STAFF REPORT O'Keefe Plat Alteration

SUBJECT: O'Keefe Plat Alteration (LP-17-00006)

Proposal: Dan Butler, agent, is proposing a plat alteration to the O'Keefe Plat, recorded in Volume 10 of Plats, at page 10, Records of Kittitas County on February 23, 2006. The proposed plat alteration would replace an existing 40-foot wide private access and utility easement and cul-de-sac easement with a relocated 40-foot wide private access and utility easement and a new 30-foot access and utility easement.

O'KEEFE PLAT - ALTERATION
A PORTION OF THE NE 1/4 OF THE SW 1/4 OF SECTION 28,
TOWNSHIP 20 NORTH, RANGE 17 EAST, W.M.
KITTITAS COUNTY, WASHINGTON
PRELIMINARY

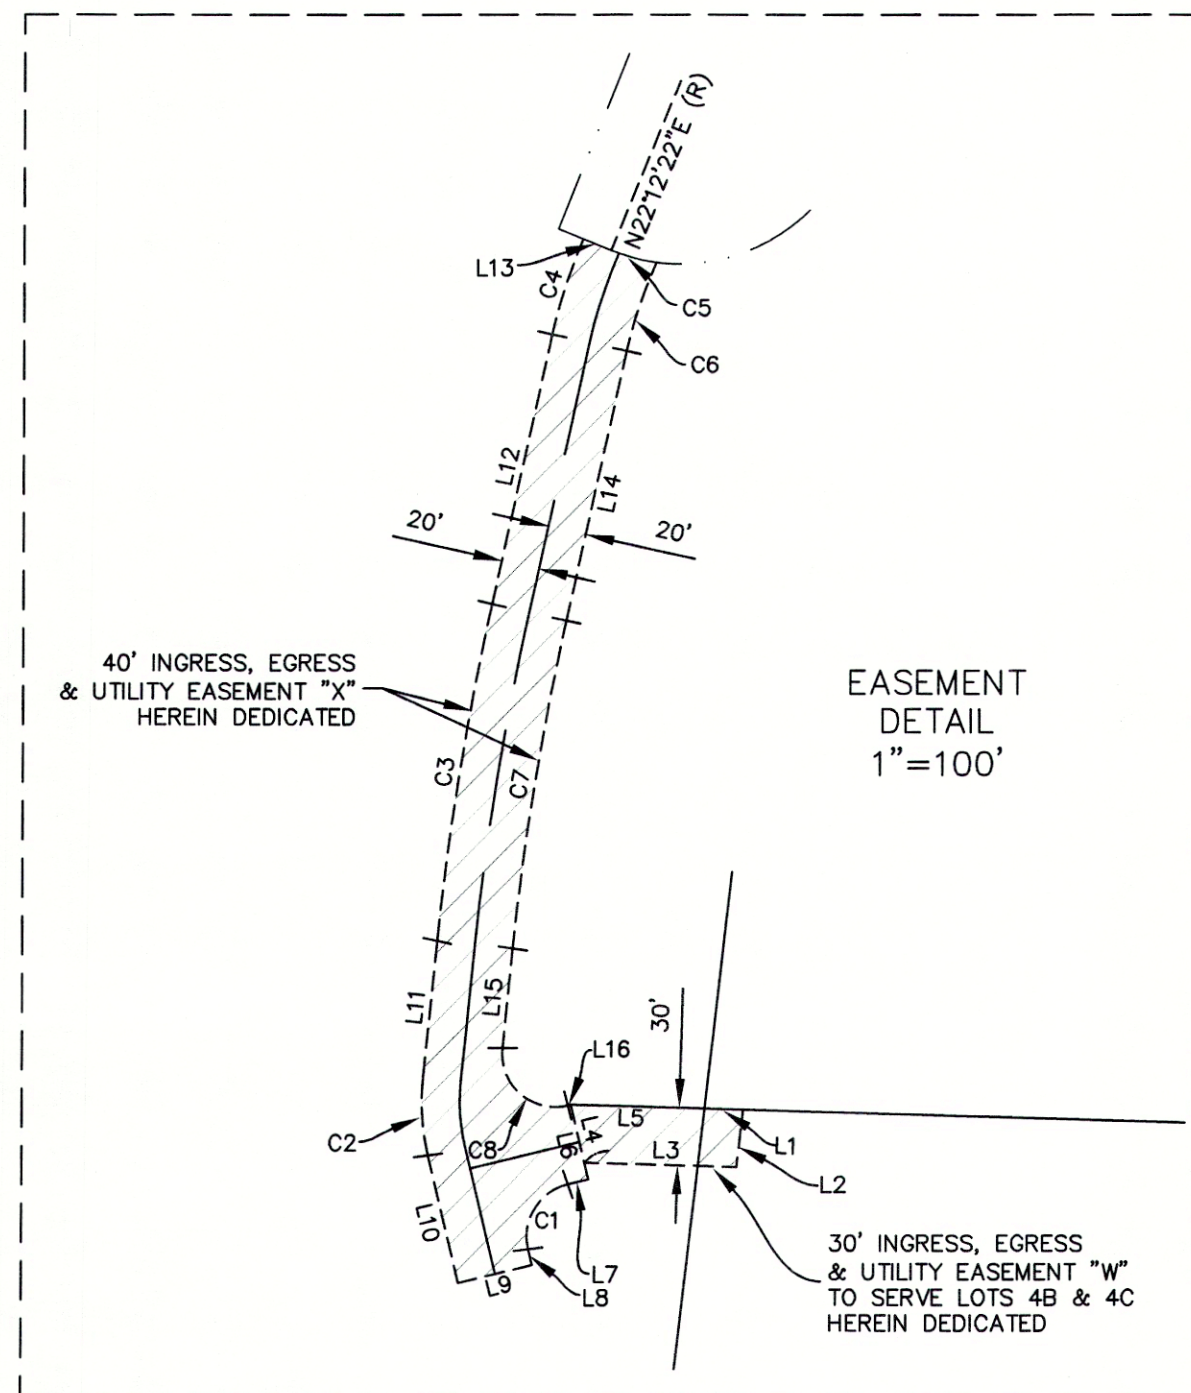
3. **Private Road Improvements:** Access Mountain Creek Drive shall be constructed to meet or exceed the requirements of a High-Density Private Road that serves 3-14 tax parcels. See Table 4-4, Kittitas County Road Standards, 12/15/15 edition.

- a. New access easements shall be a minimum of 60' wide. Existing access easements shall be a minimum of 40' wide. The roadway shall have a minimum width of 20', with 1' shoulders, for a total width of 22'.

- b. Minimum centerline radius will be 60'.
 - c. Surface requirement is for a gravel surface per WSDOT Standard Specifications.
 - d. Maximum grade is 10%.

4. Turnaround: When a road extends more than 150' from the centerline of a County road or other publicly maintained road or serves more than three lots, a turnaround shall be provided. The turnaround shall be a cul-de-sac for roads serving five or more lots/units. The turnaround may be a hammerhead for roads serving four or less lots/units or for a land use development activity occurring prior to the end of the road. Cul-de-sac and hammerhead designs must conform to the specifications of the International Fire Code. A cul-de-sac shall have an easement diameter of at least 110 feet and a driving surface of at least 96 feet in diameter.

5. Driveways: A driveway shall serve no more than two tax parcels. See Kittitas County Road Standards, 12/15/15 edition.
- a. New access easements shall be a minimum of 30' wide. The roadway width shall have a minimum width of 12' if the length of the driveway is less than 150', or 16' if the length of the driveway is more than 150'.
